AMENDMENT TO THE MDDP FOR WATERVIEW NORTH

SUBMITTAL #5 – Response to Comment

POND ID	Q(5)in	Q(5)out	Q(100)in	Q(100)out
BJD-K	28	3	55	16
JCD-D	113	12	244	100
A	26	1	47	17

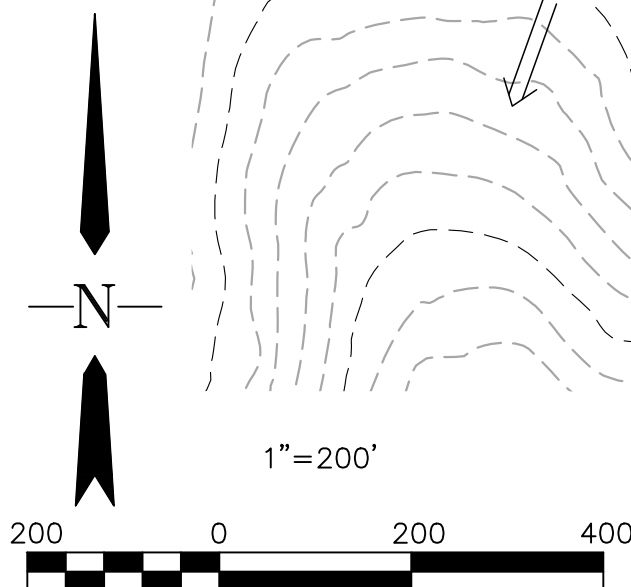
Our comparison totaling the discharge of Pond JCD-D with the bypass flows from Basins JCD OS-1A and JCD OS-1B is misleading and confusing and we have corrected our error. Our totaling of these numbers was our attempt to provide information to the county about the flow east of the property, but misled the reviewer concerning the comparison of historic onsite flows detained in Pond JCD-D and the detained discharges. We have corrected the tables accordingly.

The minor and major pre-developed peak flow rates combined from basins JCD-EX3.1 & JCD-EX3.2 are 12 cfs and 84 cfs respectively. The comparison for these historic peak flows occurs at the Pond JCD-D outlet structure. The resulting peak discharge from this pond is 10 and 83 for the minor and major events, respectively. These peak flow rates do not exceed the pre-developed peak flow rates.
